PLANNING AMENDMENT

Application No. H17/0021/01/A2

Description: Conversion of methodist church
to dwelling

**Conversion of Methodist Church to dwelling at
Station Road, Surfleet, Spalding, Lincs
Reference No: H17/0021/01**

Risers to be equal, 200mm each, treads to be equal, 264mm each. Overall rise estimated at 1800mm, size to be confirmed by measurement on site prior to fabrication of stair. Gradient of stair (calculated from rise and go given) = 37.147°.

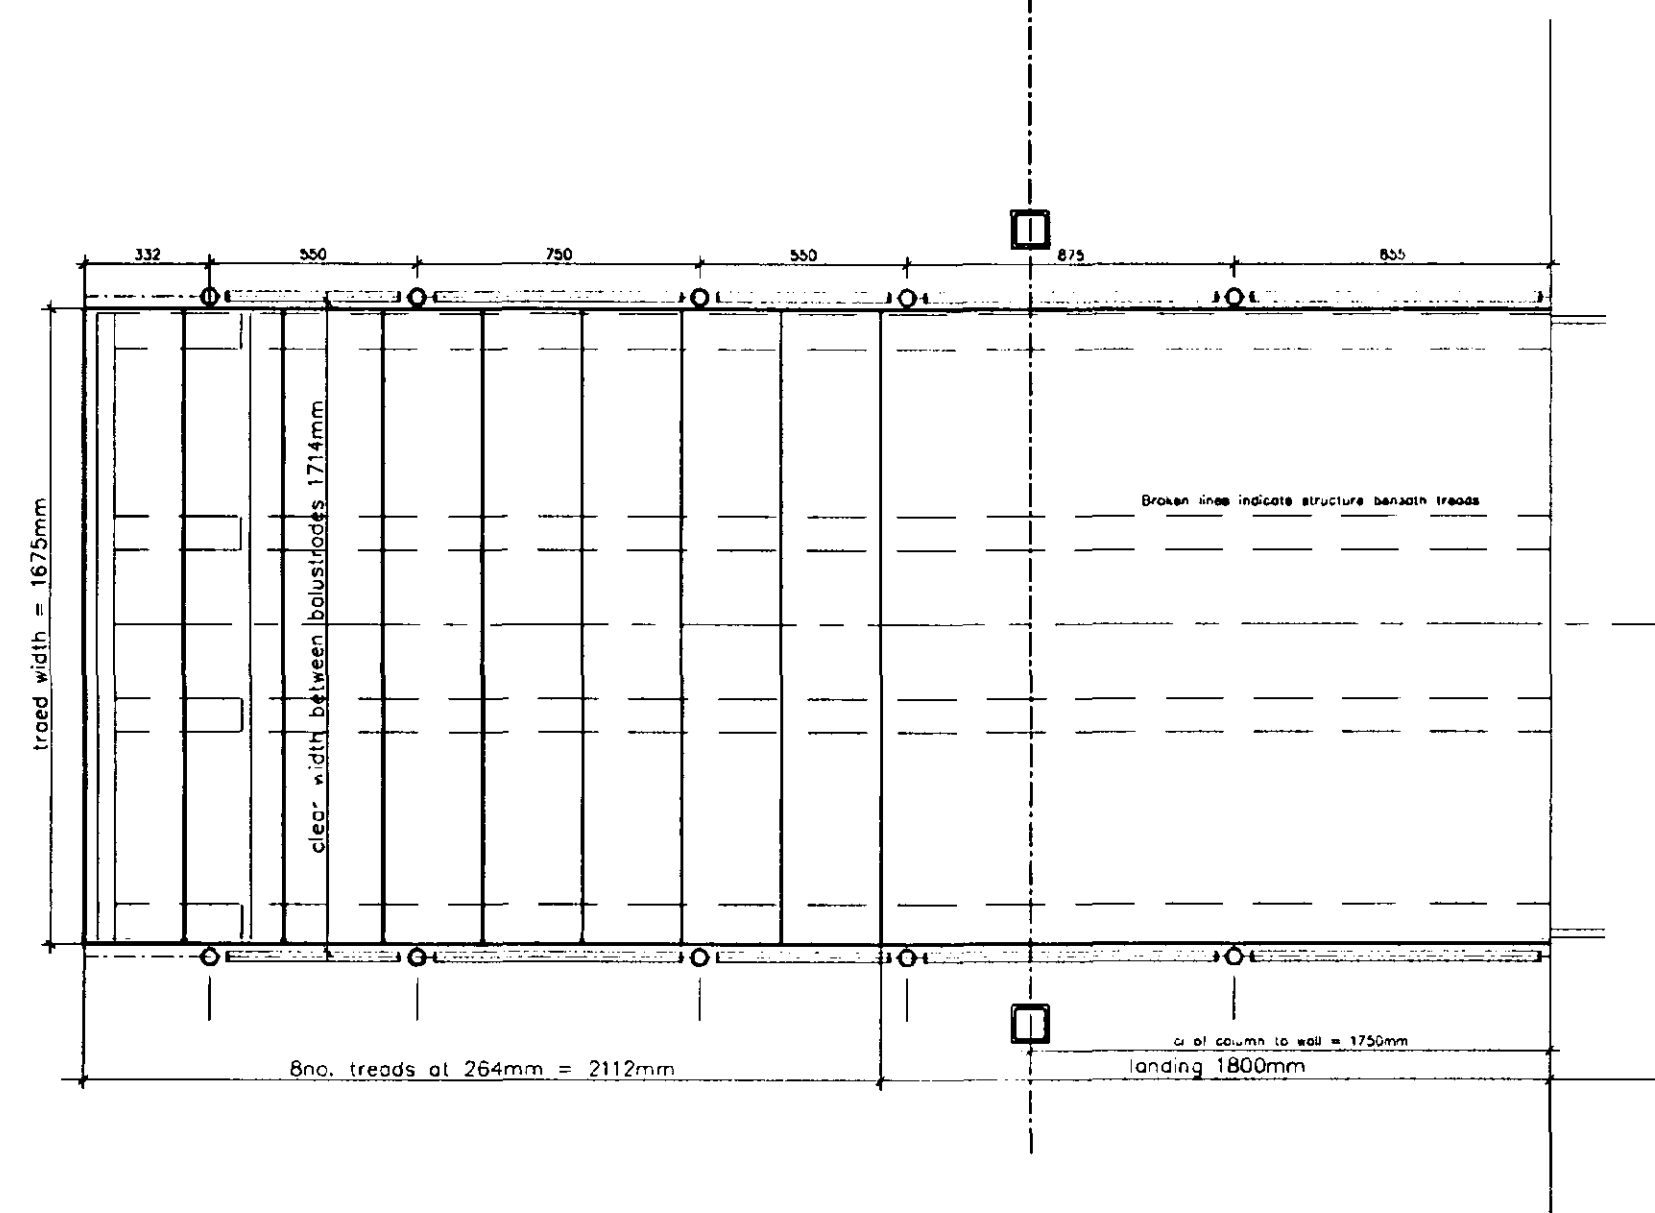
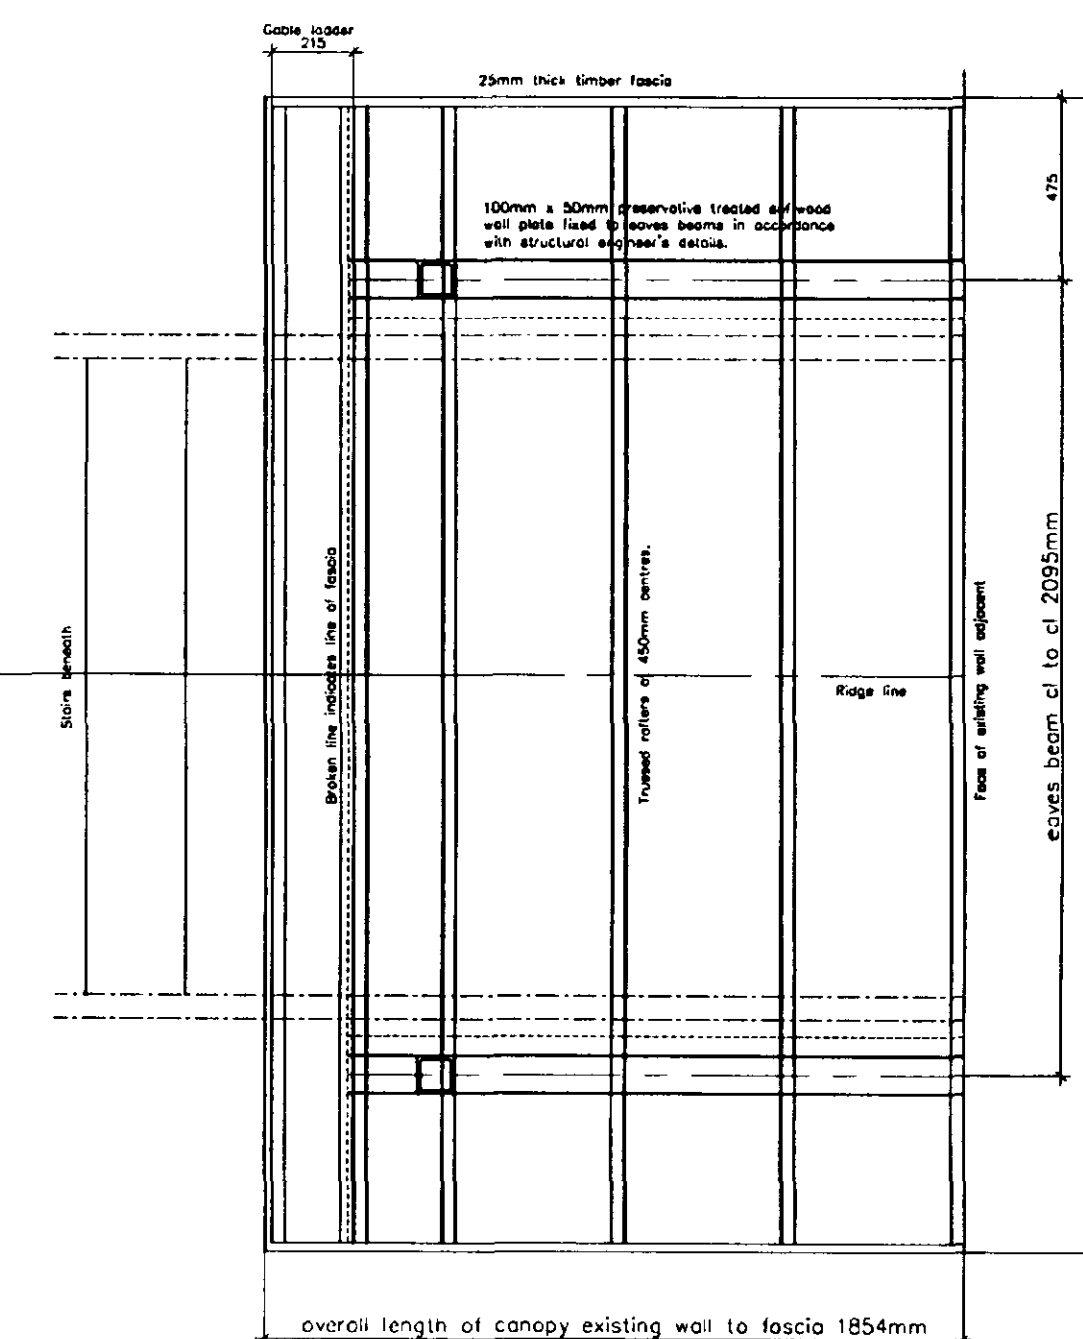
8. The balcony design has been changed and the roof canopy over has been omitted. Trellis and plant screening has been introduced to reduce overlooking of the adjacent property. In this respect we have illustrated our proposals to discharge condition number 5 of the original approval.

- 1) The balcony design, which will be submitted as a Condition Compliance.
- 2) The change to the cill height of the new window to the dining area. Such a change is contrary to Condition 9 and therefore Planning Permission is required. The window as shown on the scheme prepared by G.R. Merchant on drawing number 138/00/02, can be installed in accordance with the Planning Permission.
